**From:** Contact Centre (CRM) <contact@ribblevalley.gov.uk>  
**Sent:** 13 February 2025 16:08  
**To:** Planning  
**Subject:** Planning Application Comments - 3/2024/1016 FS-Case-687405641

**Planning Application Reference No.:** 3/2024/1016

**Address of Development:** 1-7 The Picture House, George Street, Whalley, BB7 9TH

PROPOSED REAR ELEVATION

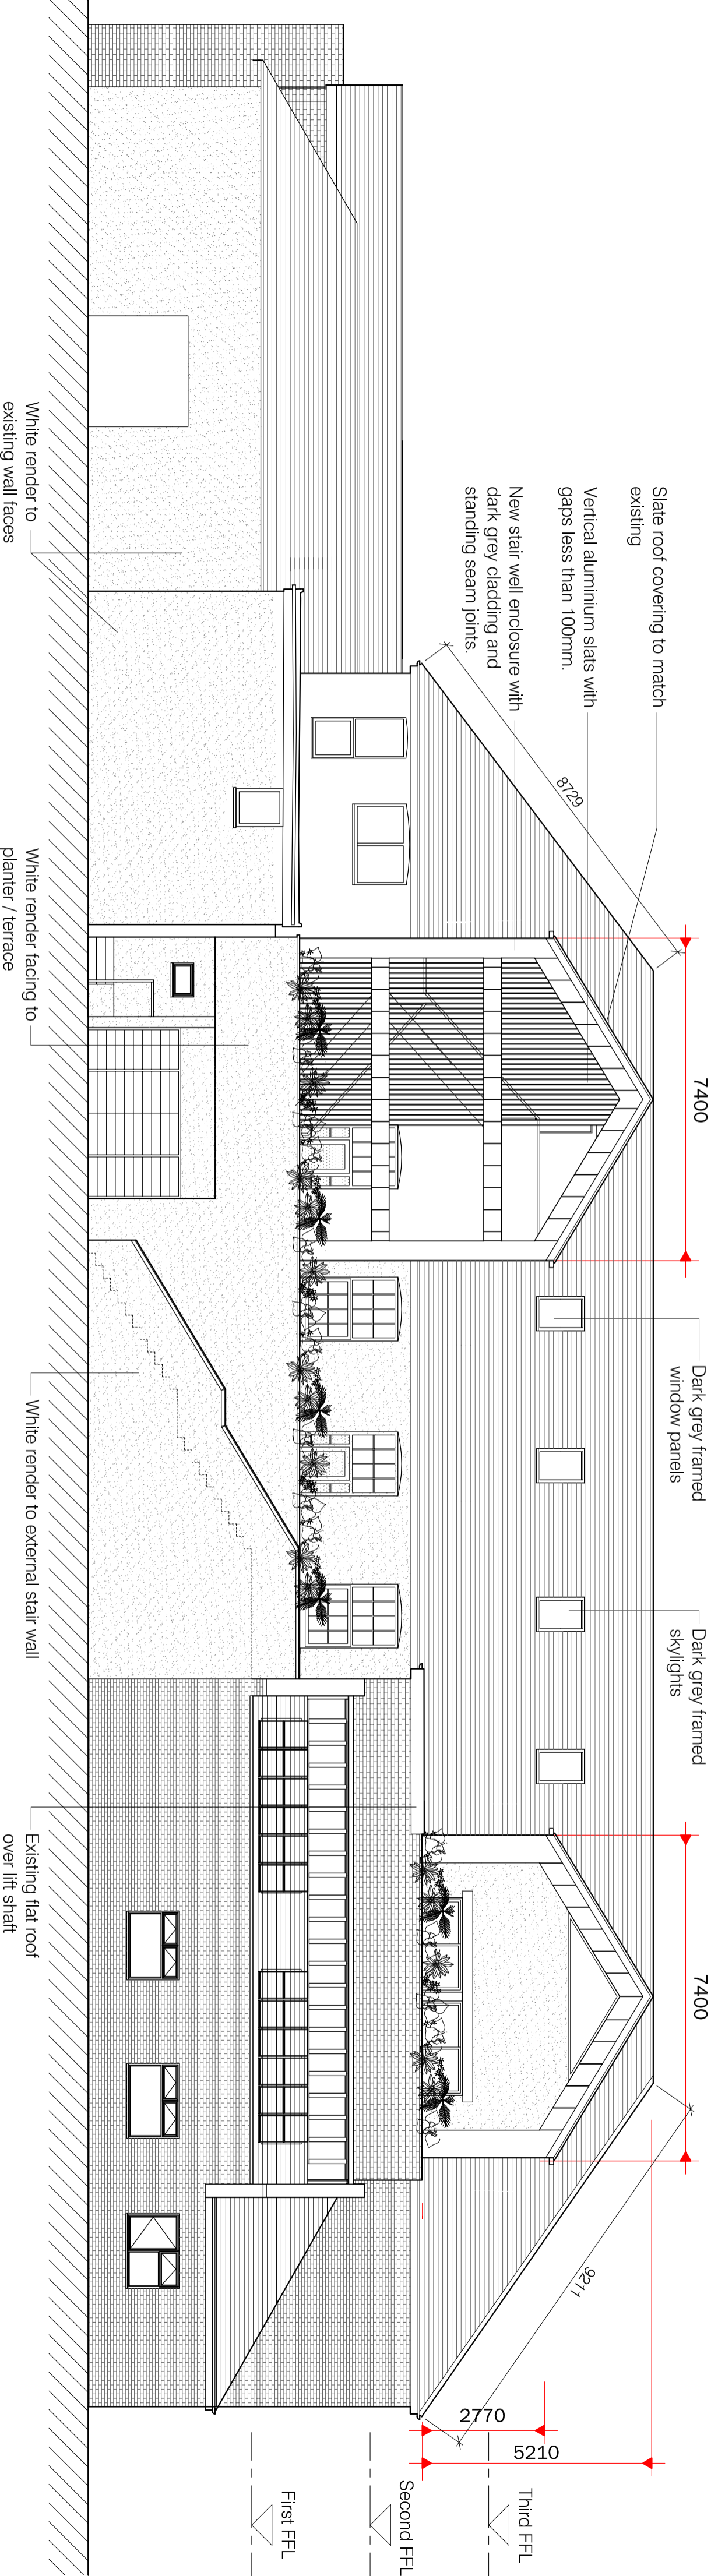
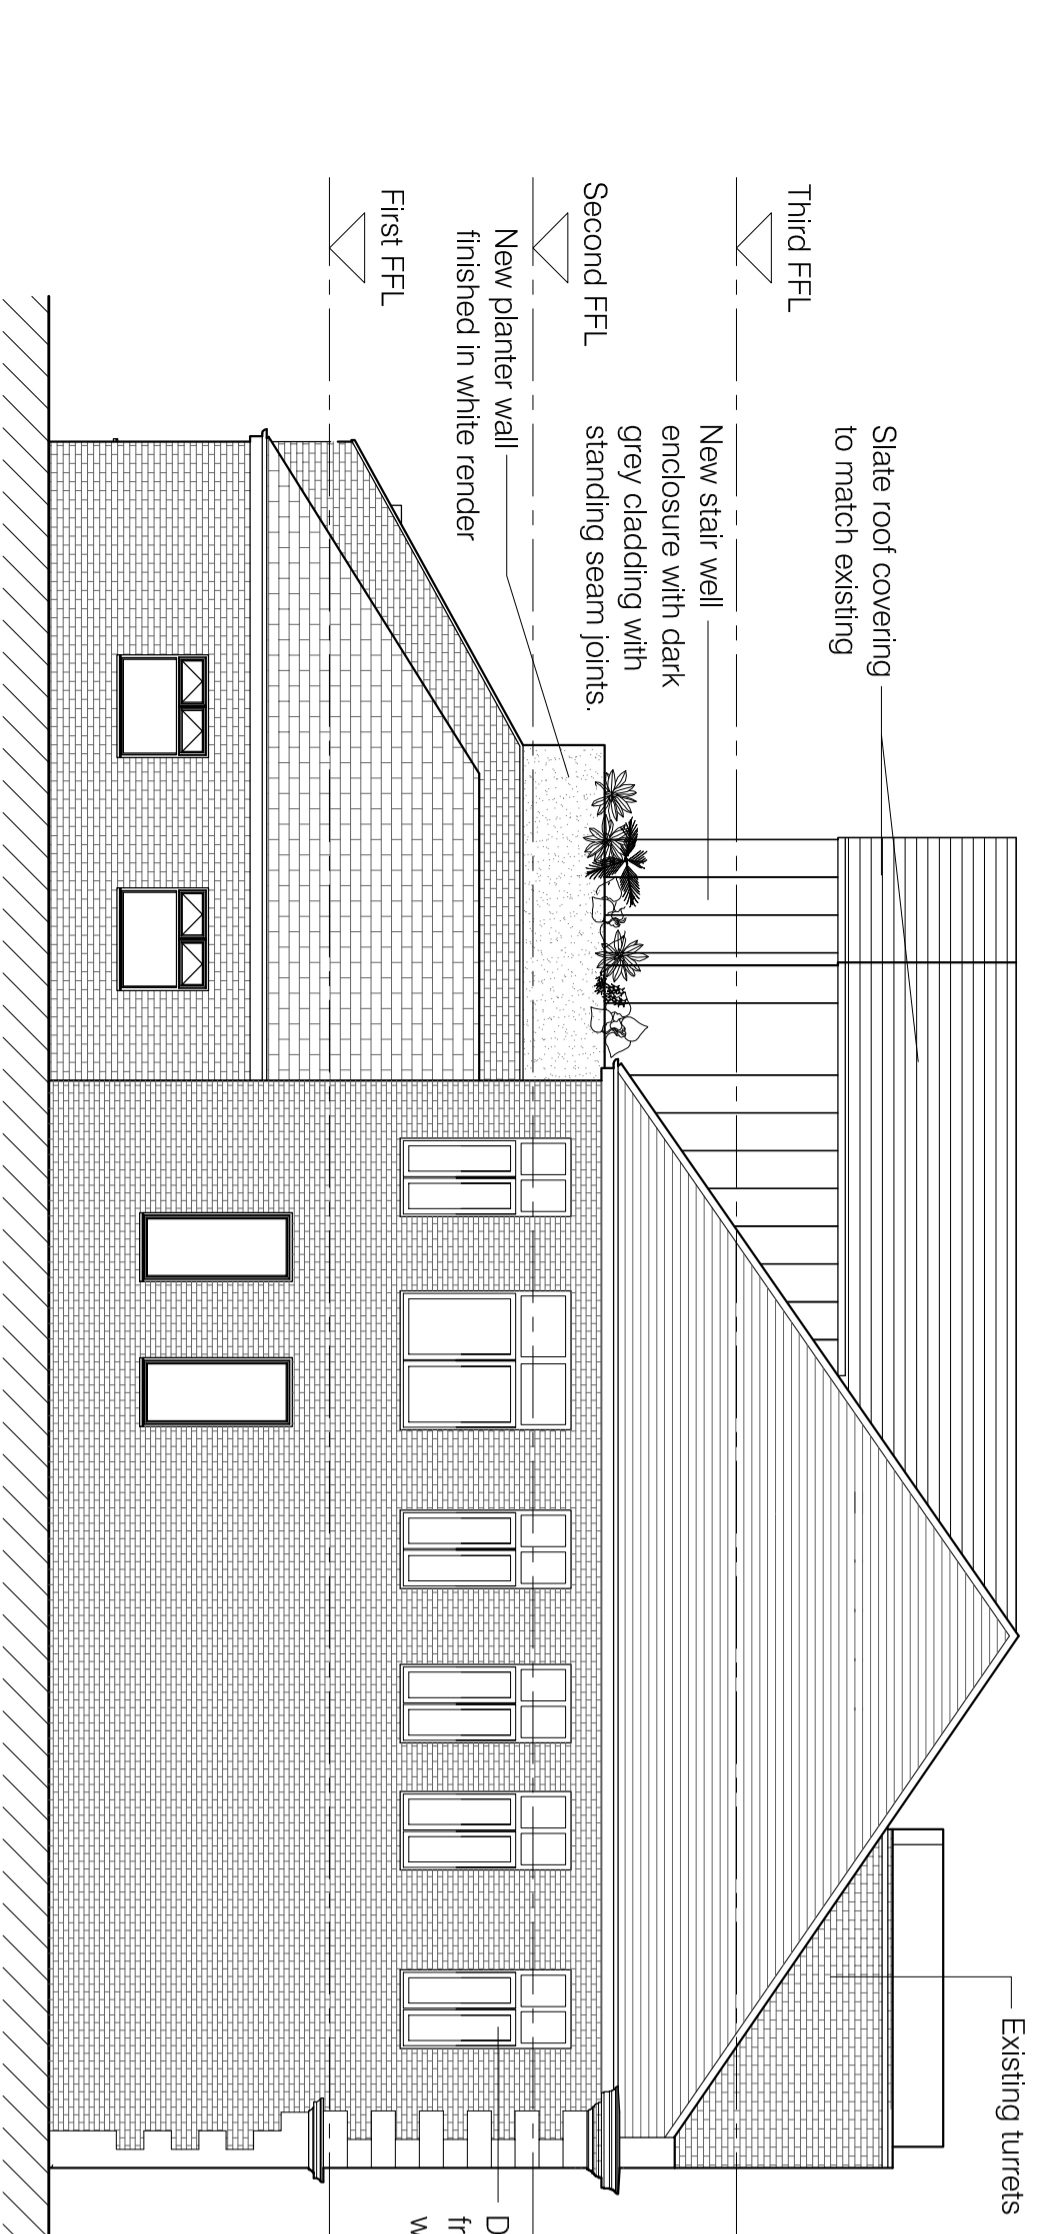
1. The rear stair well has been completed as an incongruous open canopied arrangement and not enclosed by glazing and timber boarding.
2. The rear stair well has been externally and internally finished with an aluminium standing seam cladding system and not zinc (heritage material).

4. The privacy screening to the terrace level has not been installed.
5. The rear boundary wall situation is not as the approved details and the new rendered wall to the stair has an unacceptable bulk and appearance

Lighting schedule - refer to photo sheet  
 L8 - wall mounted light fitting fixed at 1.8m above landing level

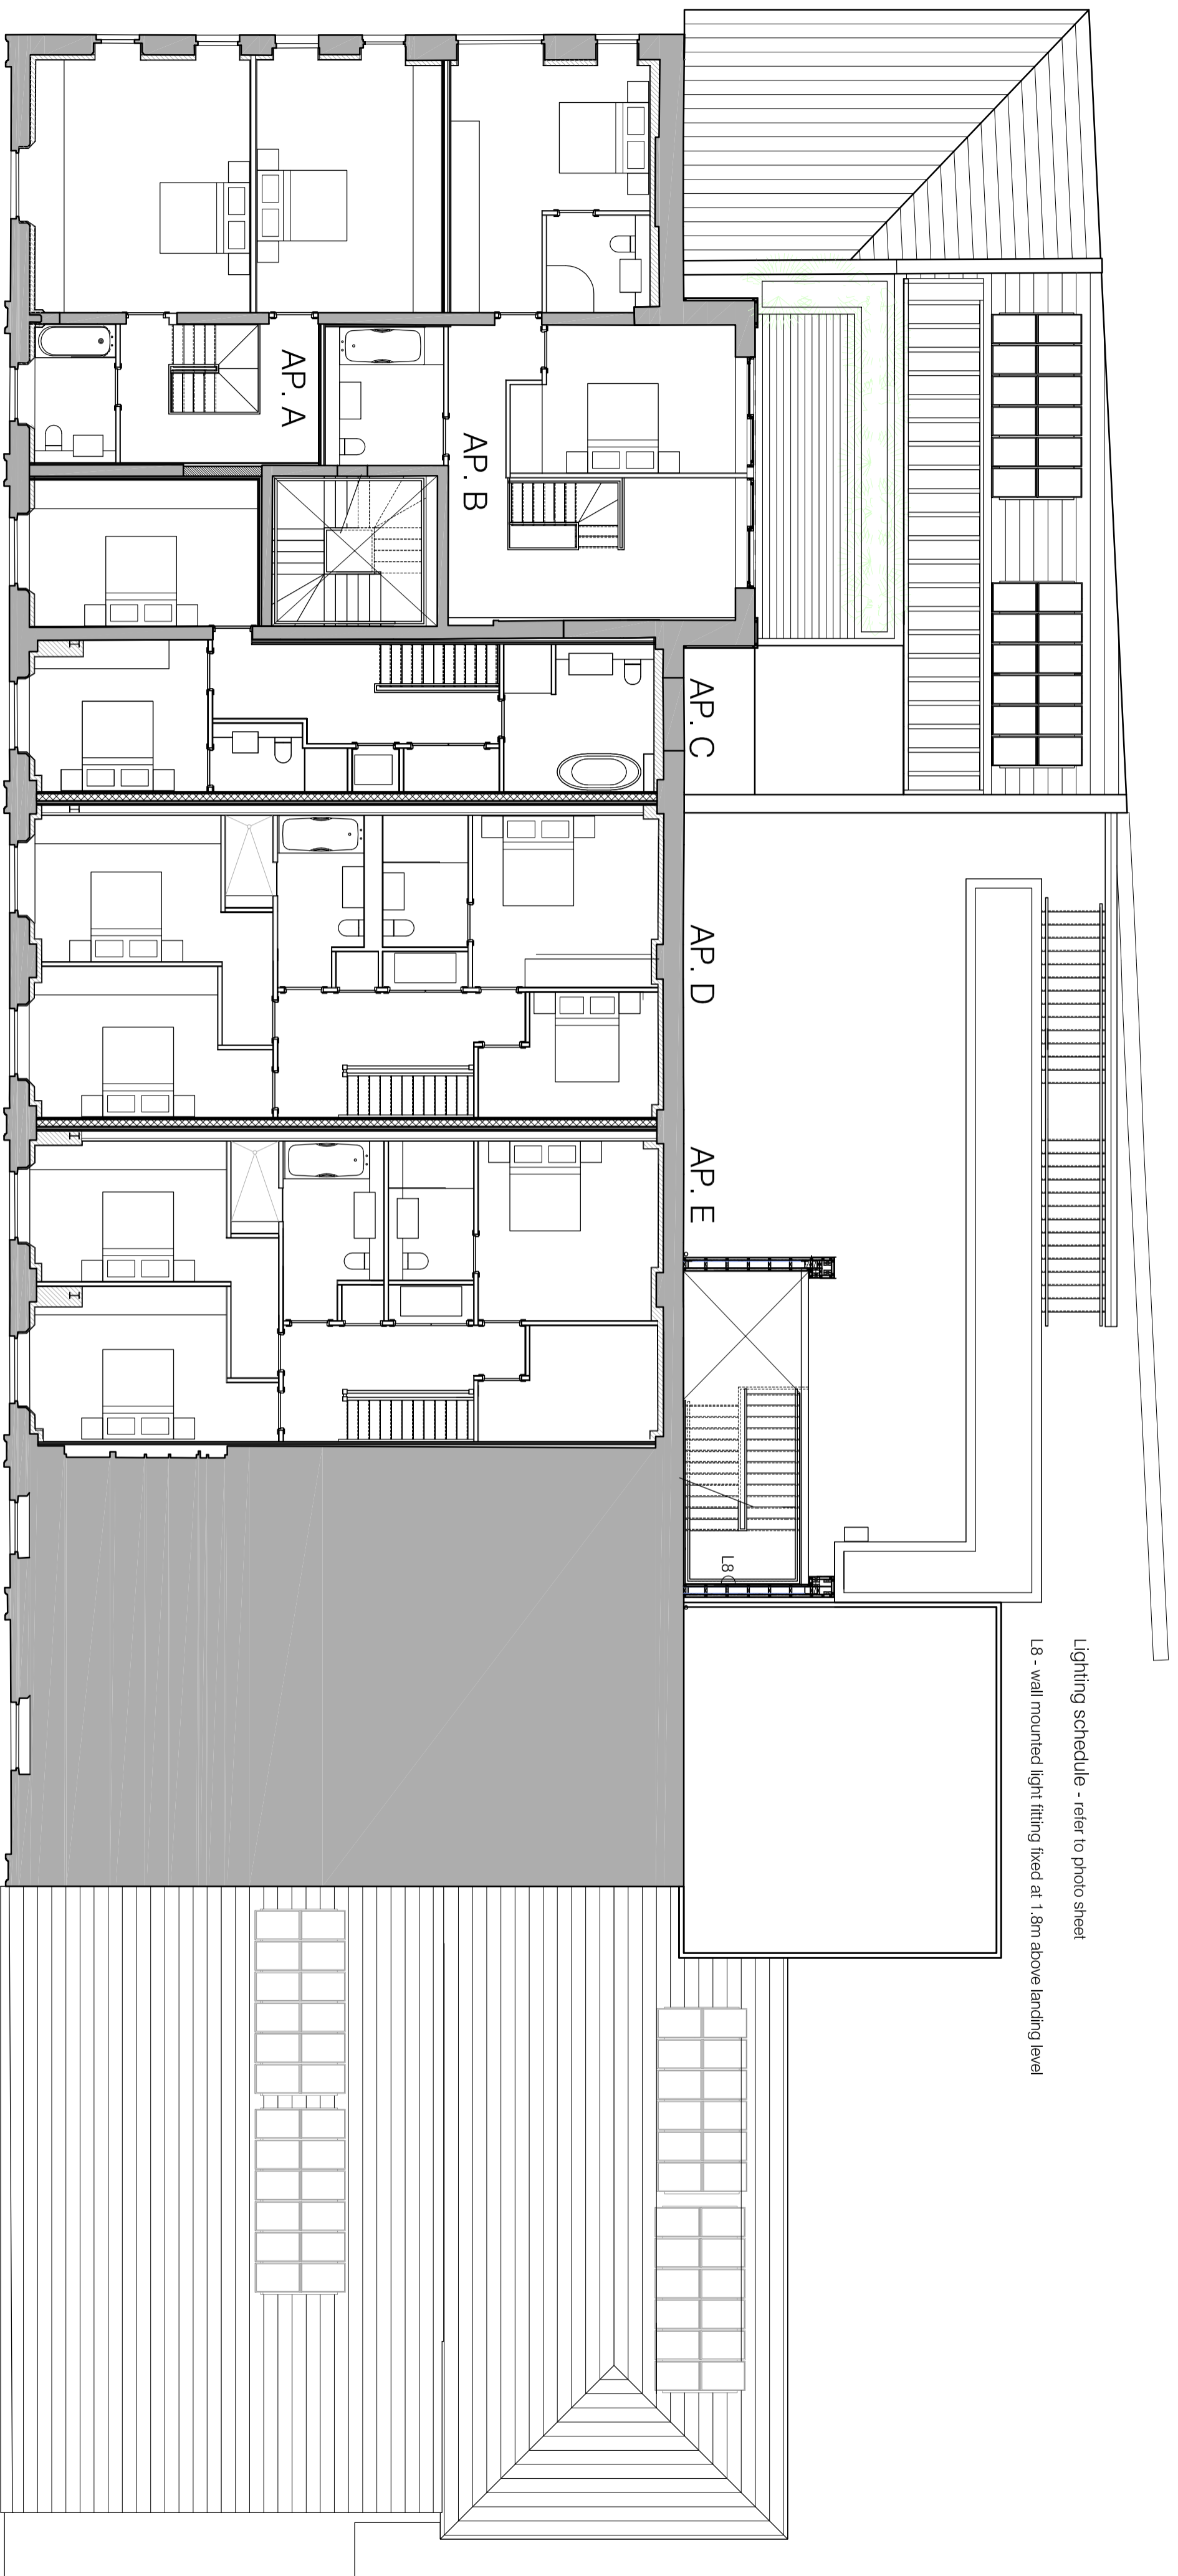
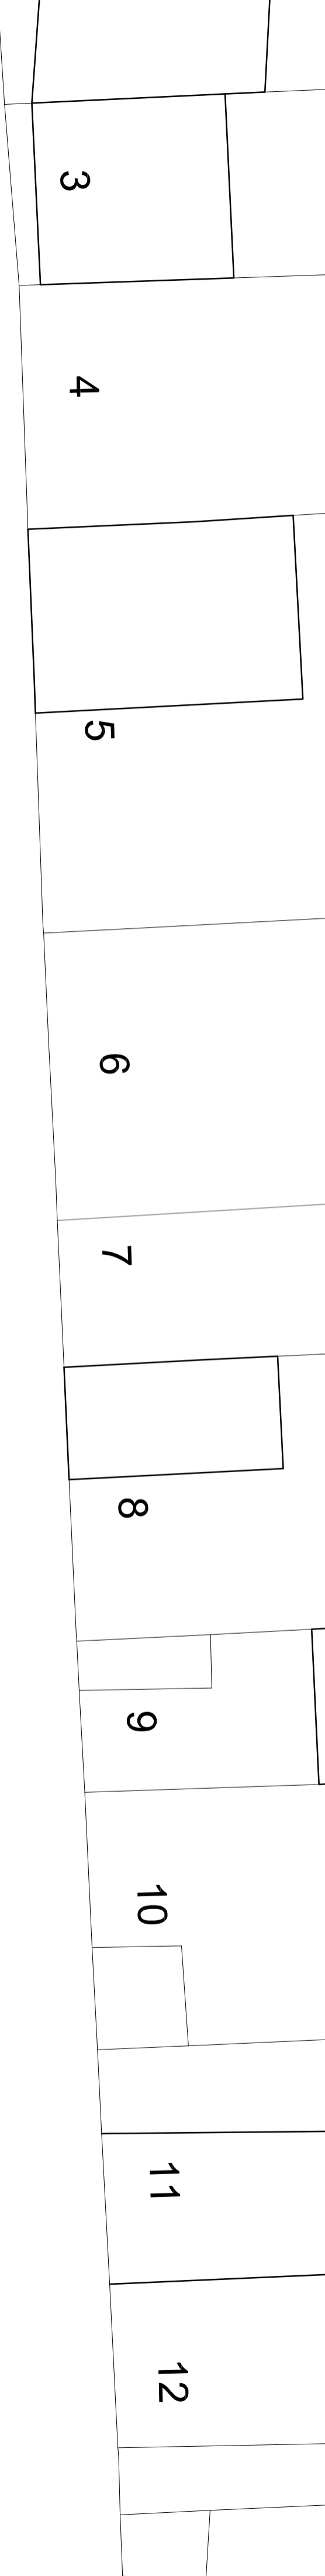
3. The rear stair well has lighting installed to a level which is completely unacceptable which is only exacerbated by the fact that it has been left open to the elements.
